**Harvests
Norton Lane
Norton
Chichester
West Sussex
PO20 3NH**

29th June 2026

Objection to Planning Application – AL/20/26/PL – DRAINAGE

I also refer to the document 'FRA/Drainage Statement/Foul Drainage Impact Assessment Rev P05' posted on 15.06.26. Title – 'Flood Risk Assessment/Drainage Statement/Foul Drainage Impact Assessment'

**PROPOSED DRAINAGE LAYOUT**  
SHEET 1 of 2

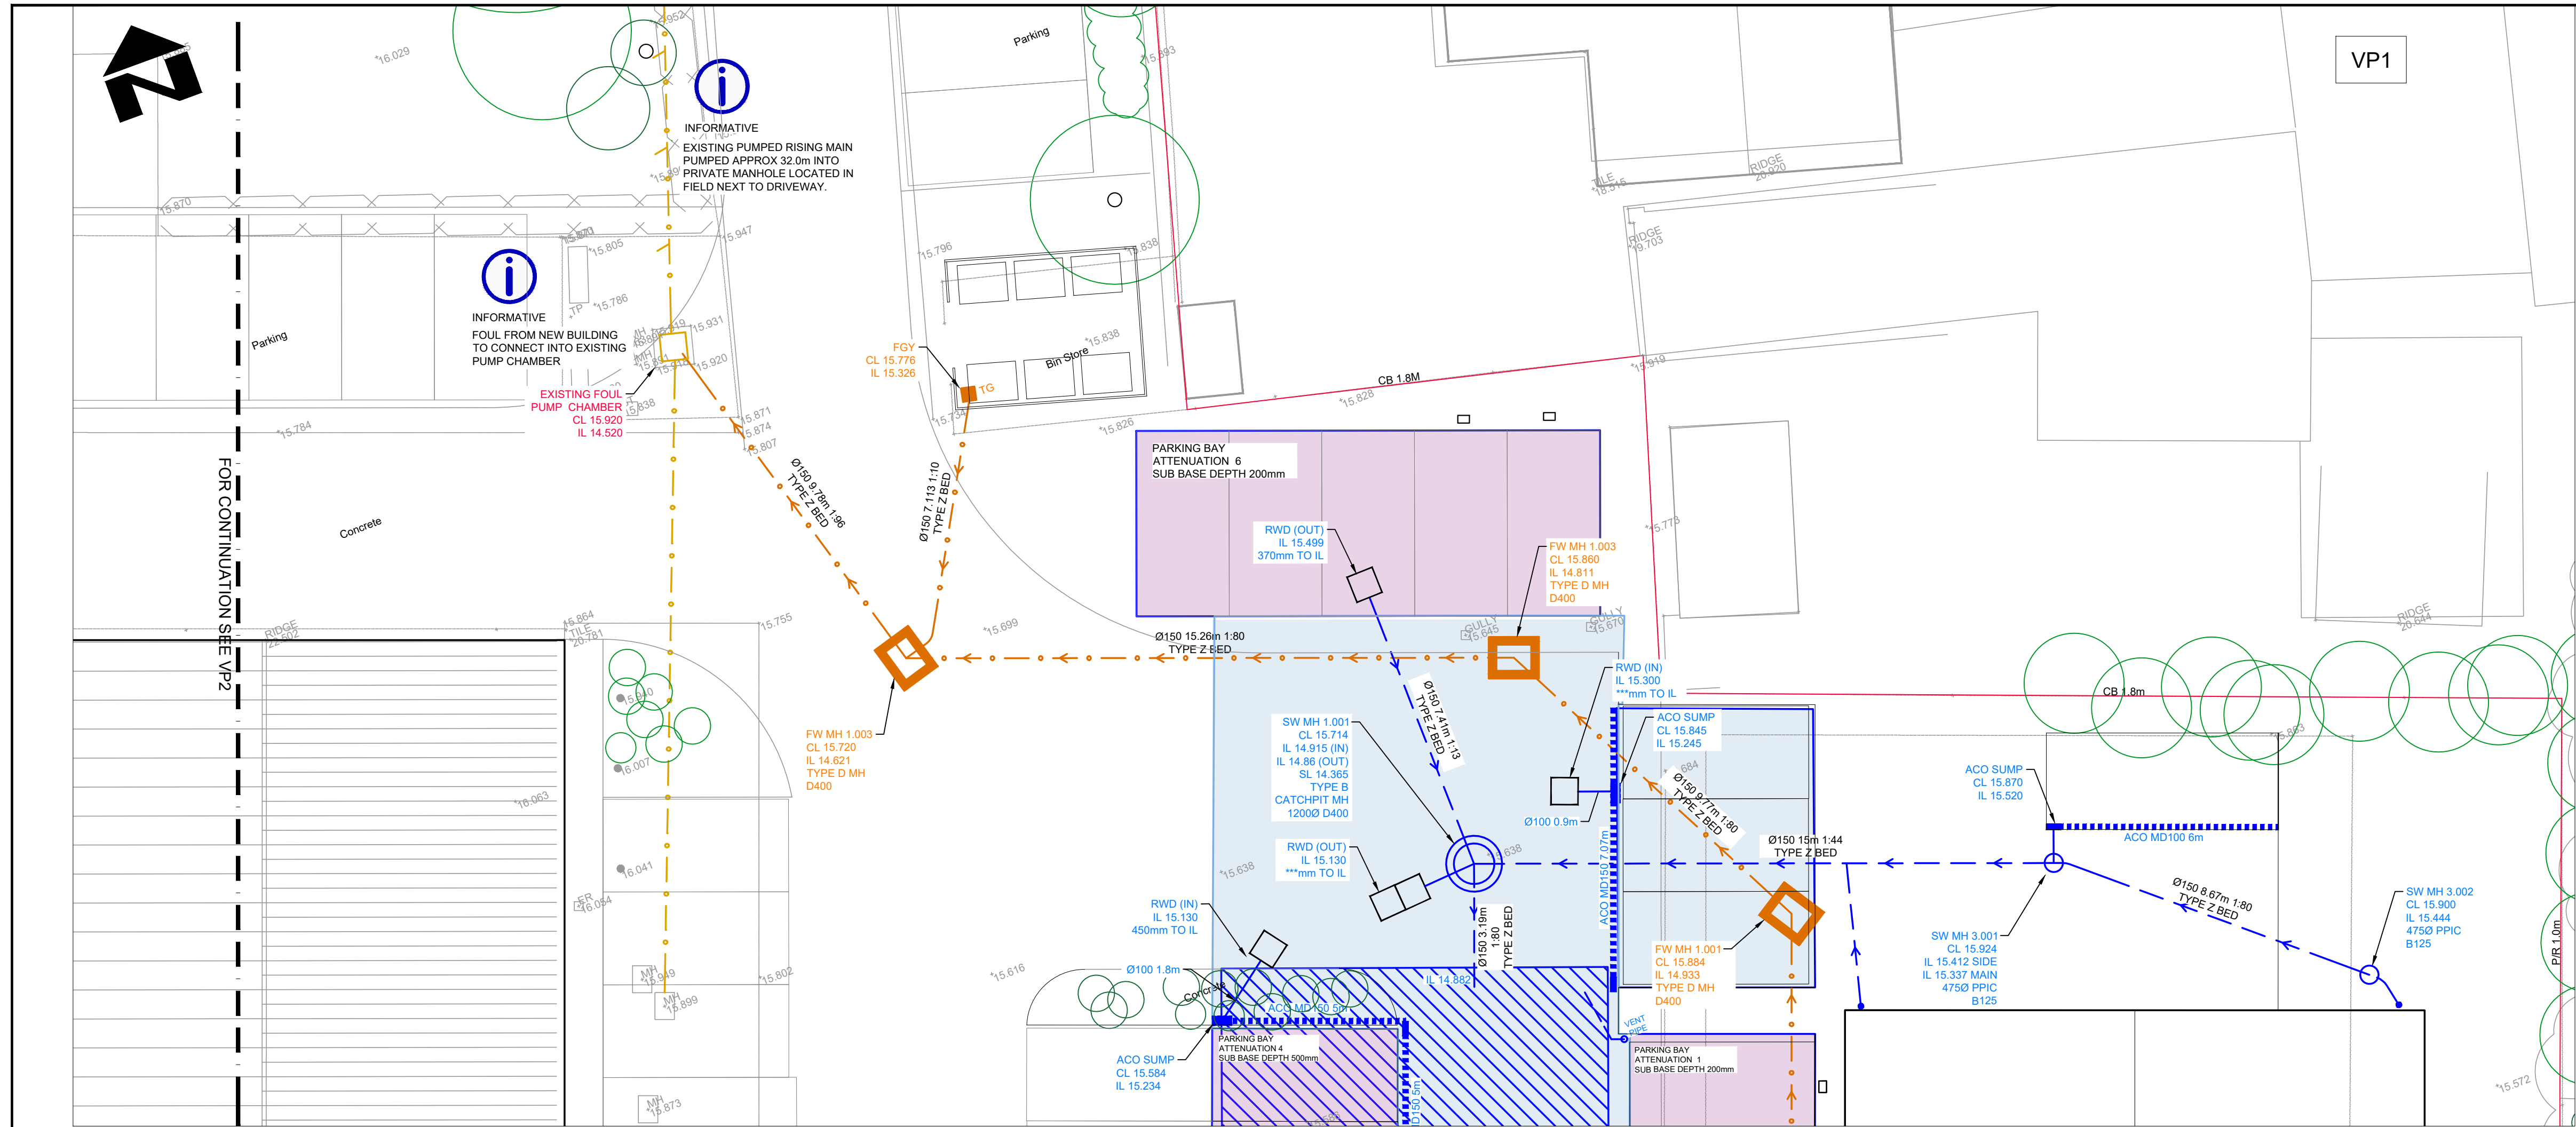
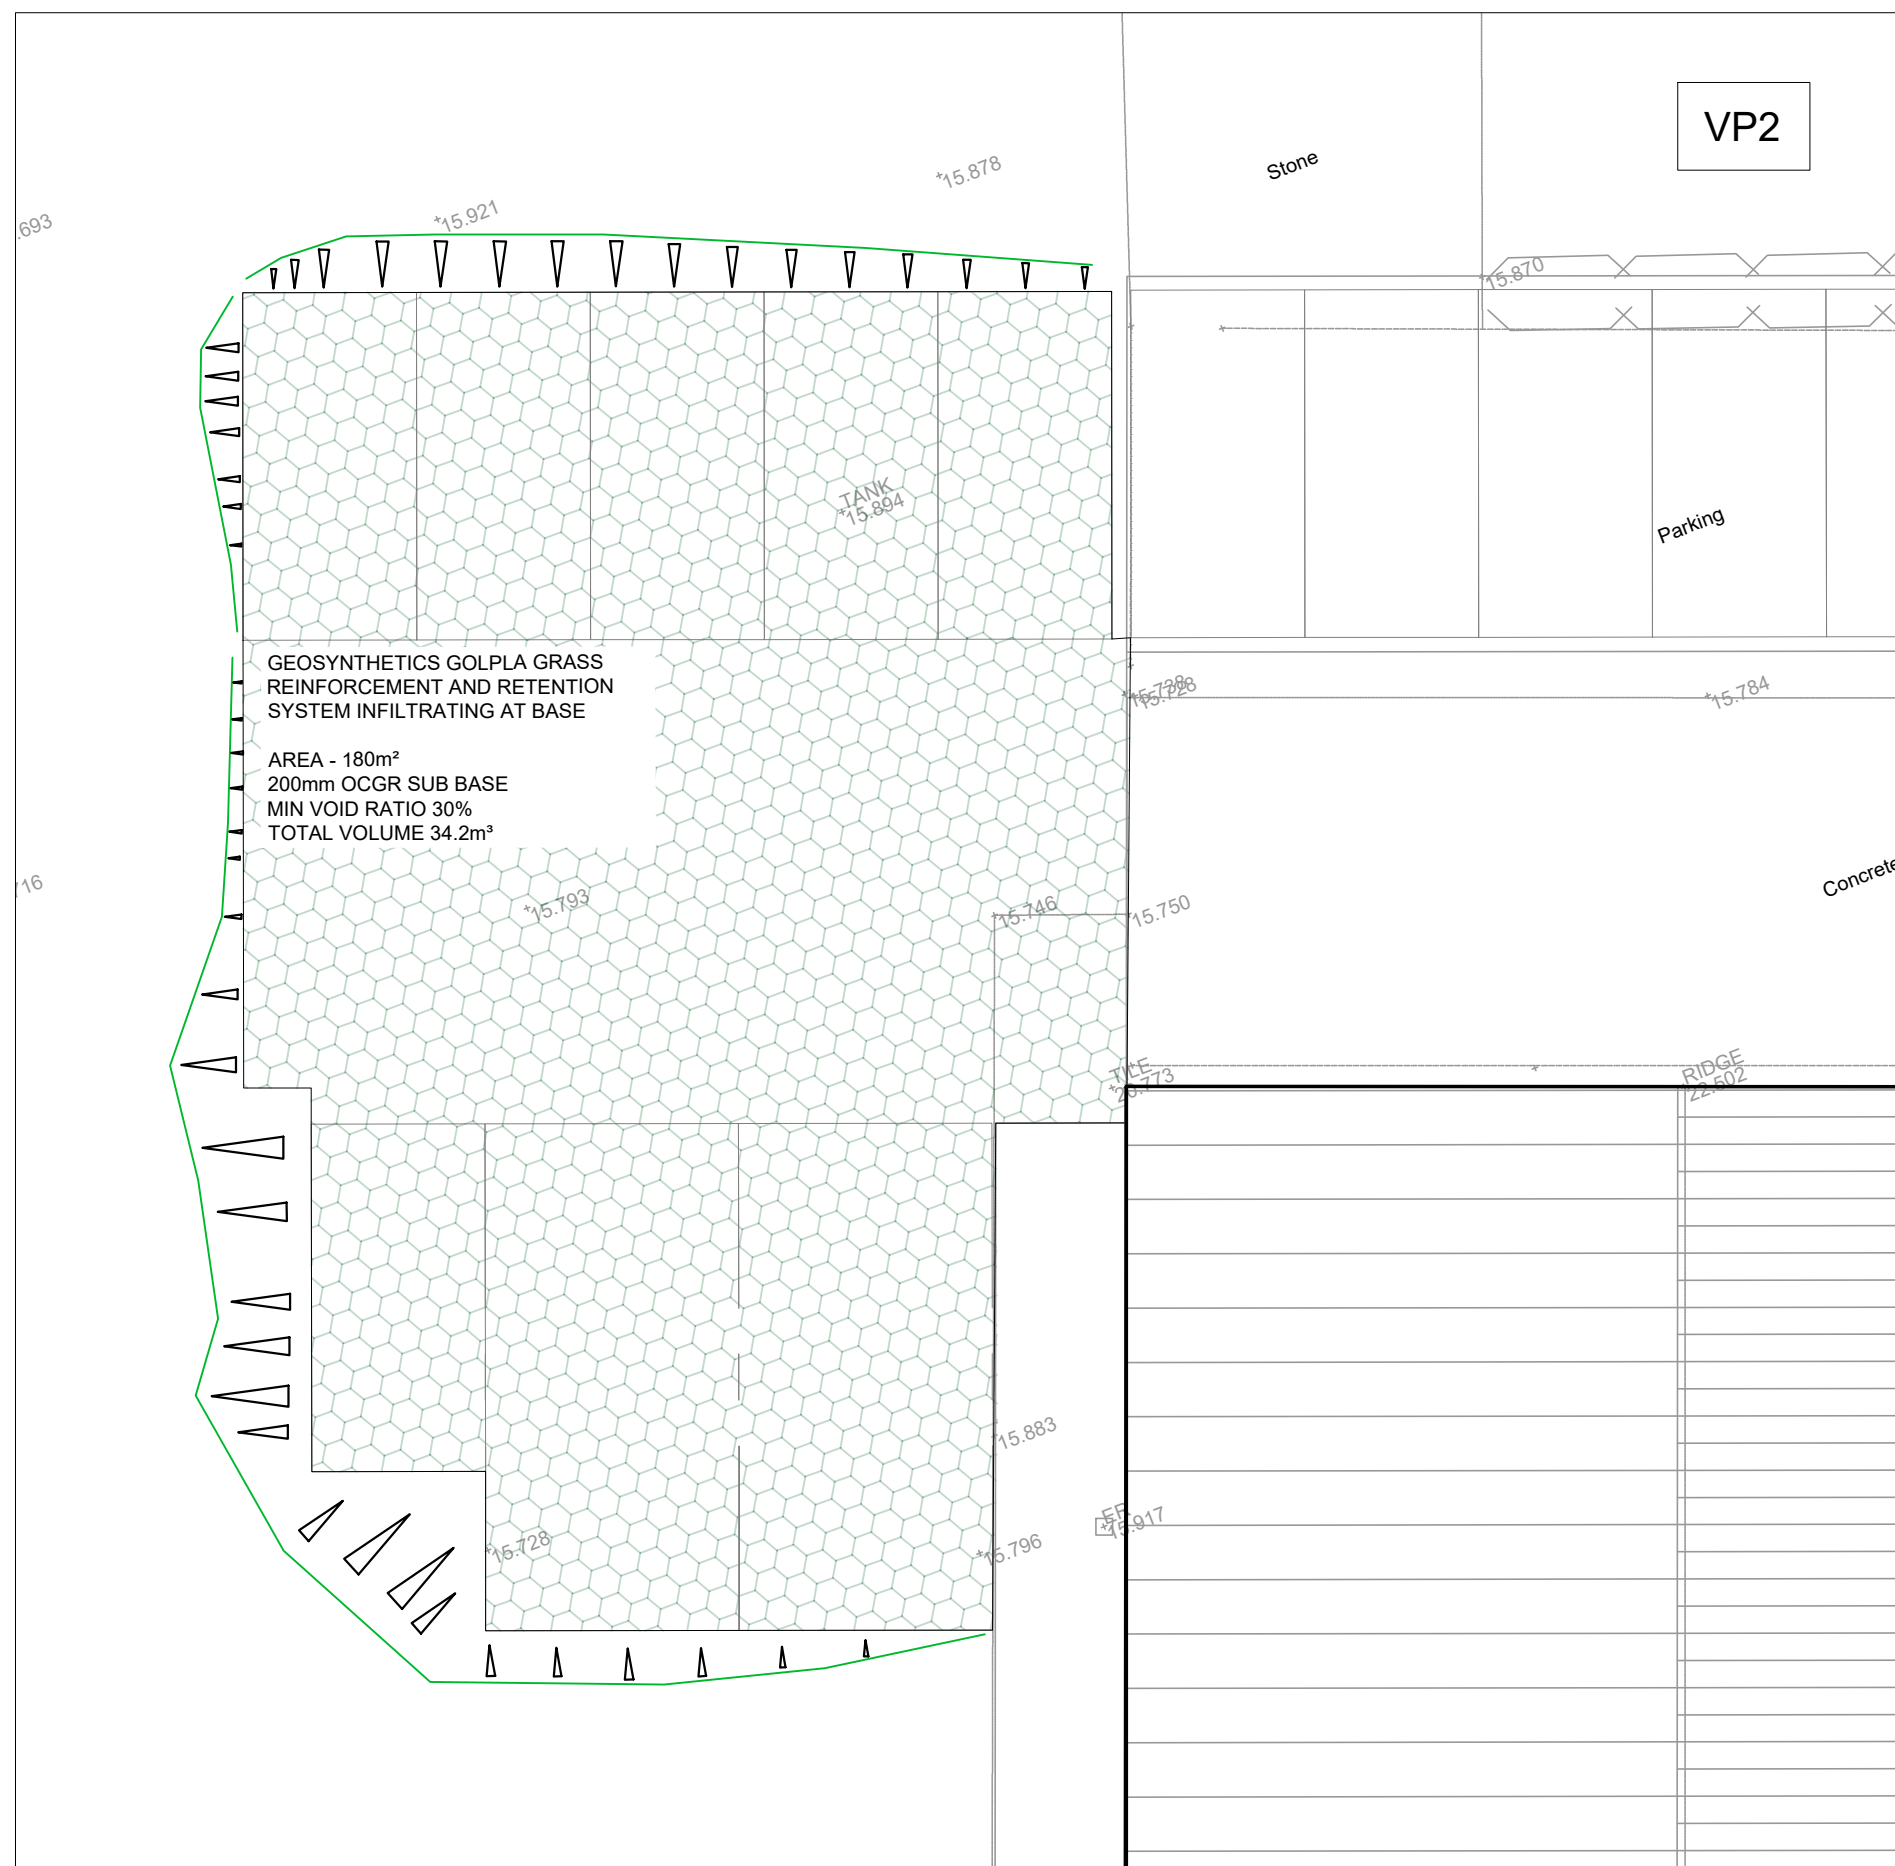
These tests were carried out at 2.2m depth which is not at the soakaway level and hence inadequate. This inadequacy is acknowledged by the Applicant's Agent as further down in 4.1.10 we have;

These tests may well be at a more appropriate level but they were carried out in June 2026 in very dry conditions. It would be more appropriate to carry out such tests over the winter period to March when groundwater levels would be at their highest.

- 1.4. The proposed soakaway has been adjusted to be larger in plan and less deep to mitigate the risk of high ground water. The highest groundwater level for the current data is 2.2m below ground level. The proposed soakaway is approximately 0.8-0.9m below existing ground levels. The base therefore has a margin of buffer before the 1m vertical offset which is acceptable on a precautionary basis to mitigate the possibility that the annual peak had not been fully reached at the end of the groundwater monitoring.

This reinforces the key issue that testing has not been conducted at the appropriate time i.e. when groundwater levels are at their highest. It is somewhat unfortunate that the Applicant received apparently inappropriate advice from ADC in a pre-application enquiry. To rectify and overcome this inappropriate advice / agreement a period on winter groundwater monitoring should be undertaken to include the period when groundwater levels are at their highest (March).

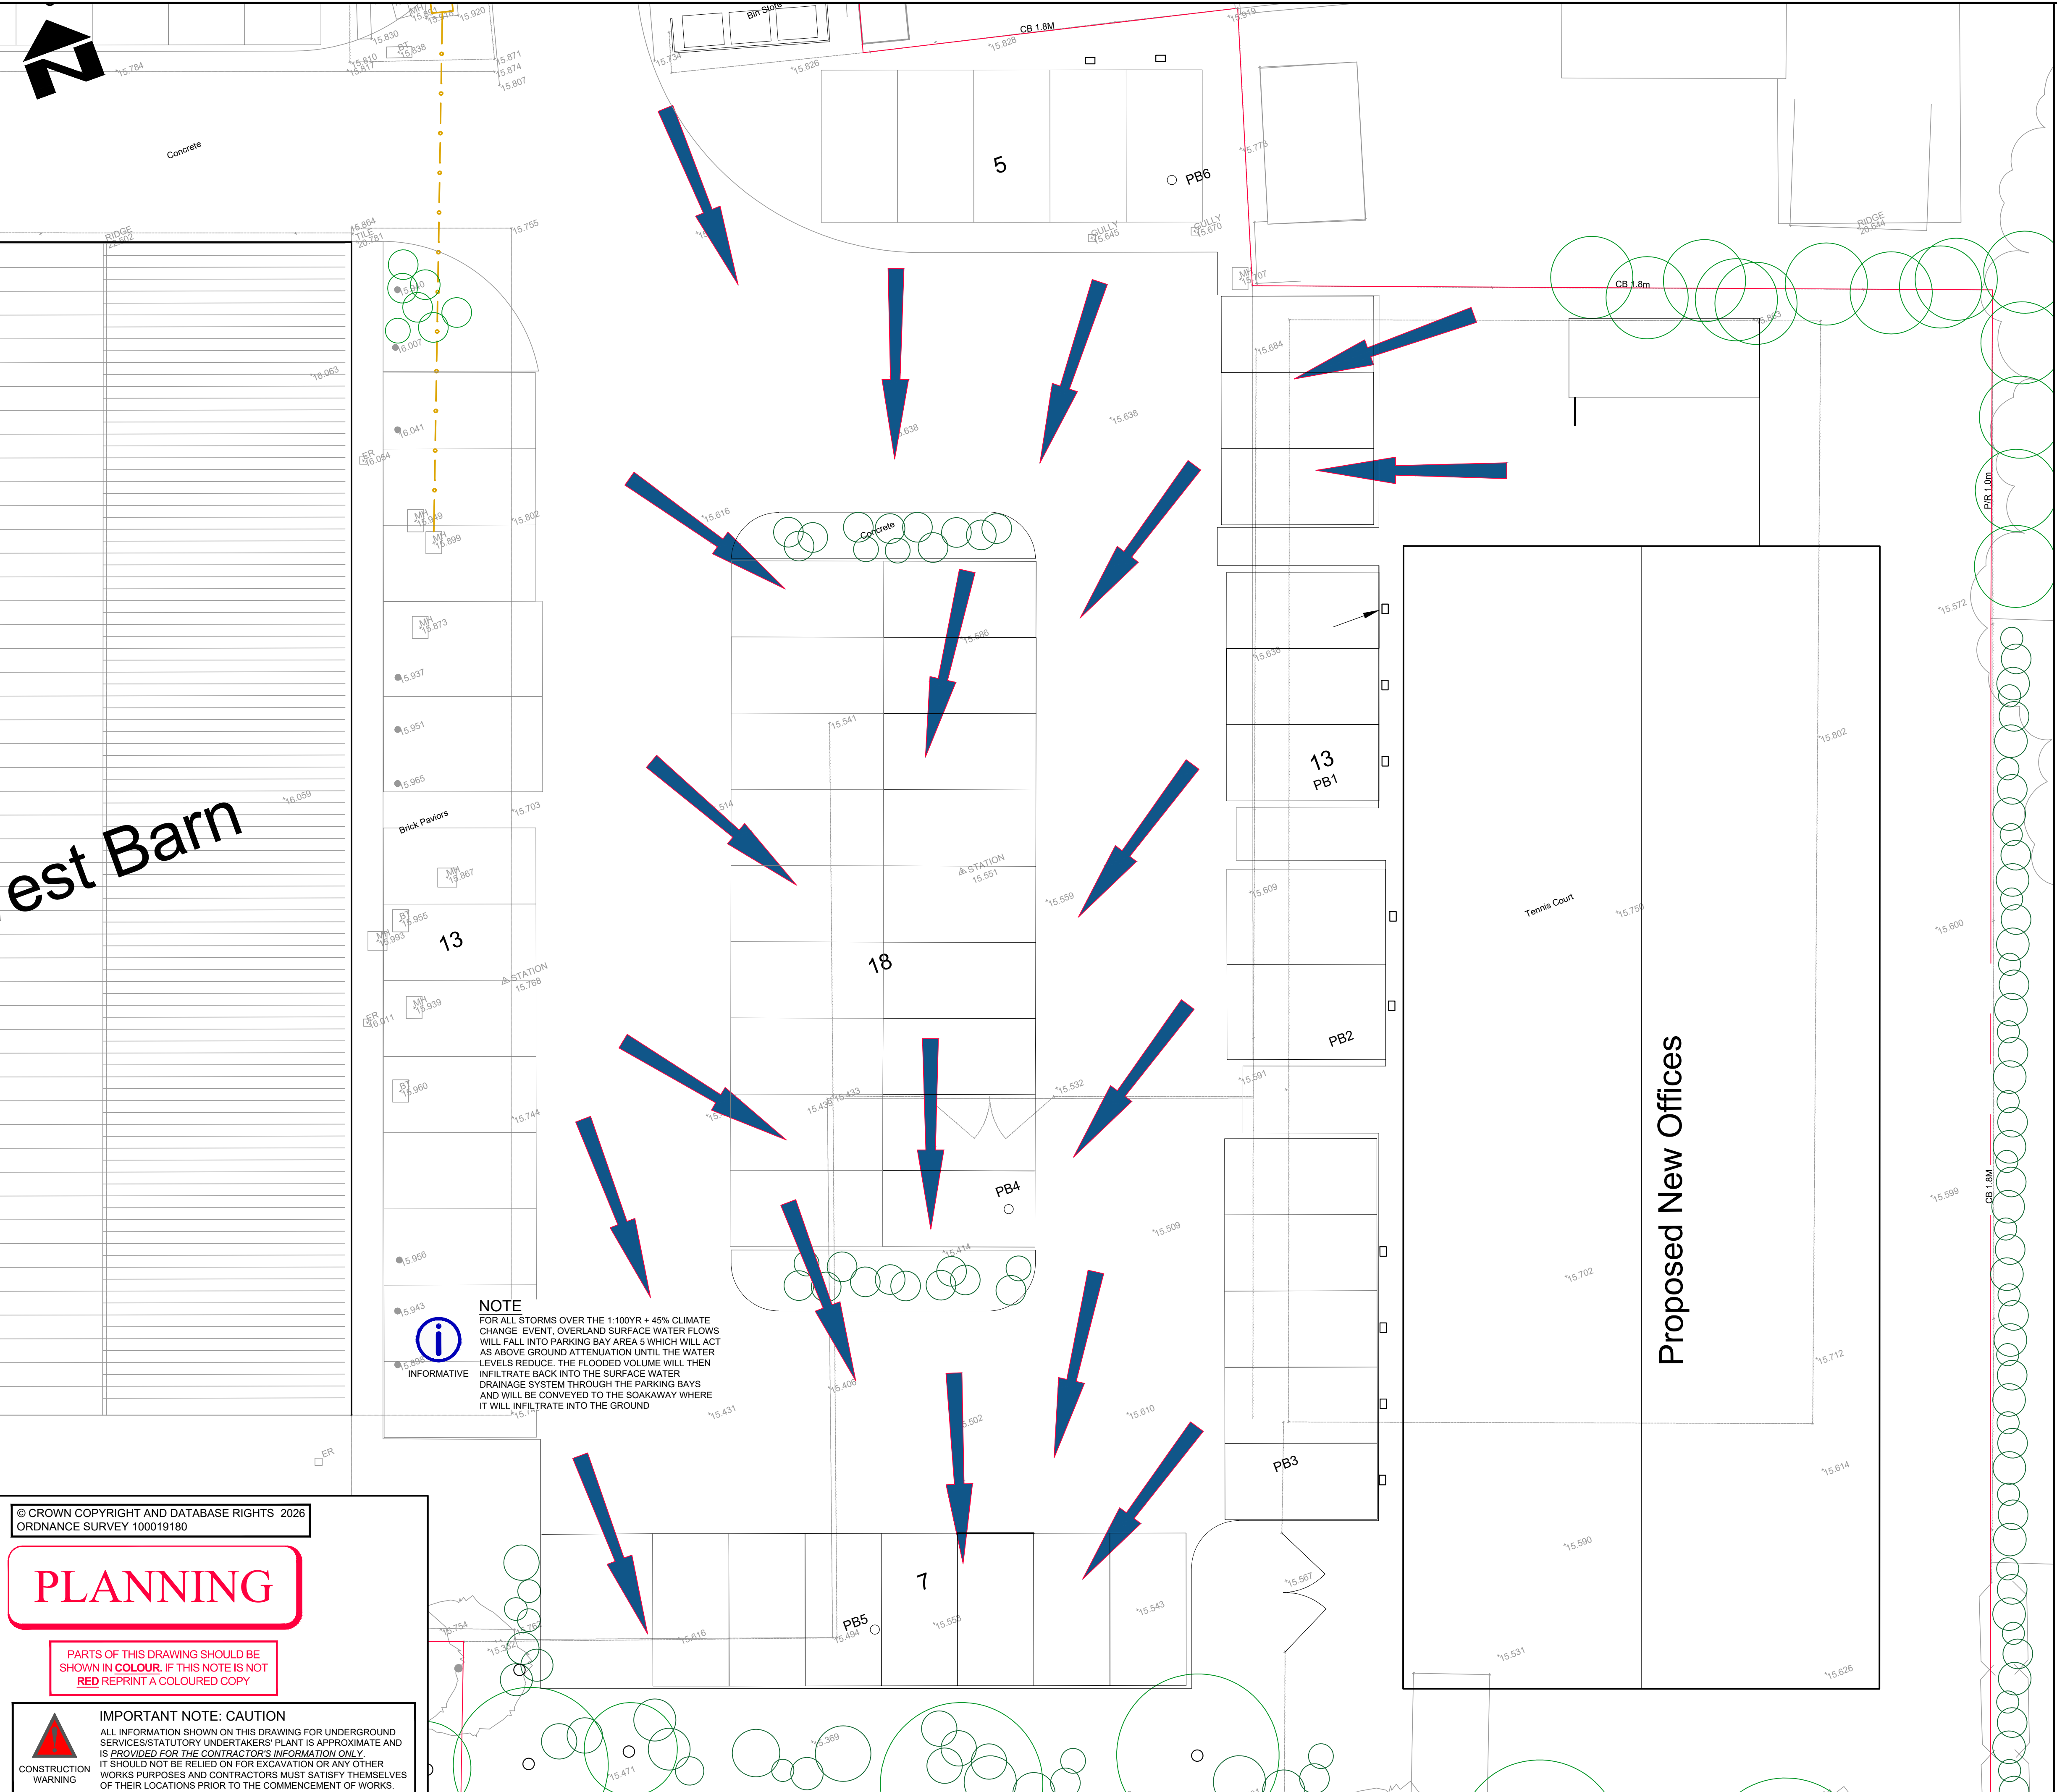
- 8.1.6 Exceedance routing has been designed as such there are no existing, proposed or third party land at risk following the event of failure in the system or storms greater than 1:100yr +45% climate change event.

'In this instance, any rainfall event exceeding the 1:100+45% Climate Change event will flood in the southernmost parking bays at the site's low end. The hydraulic model confirms this. If the flood level breaches the kerb height of the parking bays, any volume of water would flow above ground across soft landscaping towards the site boundary.'

These two extracts are not consistent; one says 'there are no existing, proposed or third party land at risk' whereas the second says 'any volume of water would flow above ground across soft landscaping towards the site boundary' (see notes on the existing situation below).

From my letter of 20th May providing additional evidence it is quite evident that off-site flooding already occurs via this route and the proposed development will only exacerbate this problem. The still image below is taken at the rear (Southern aspect) of the existing West Barn looking across neighbouring property only a few metres from the boundary.
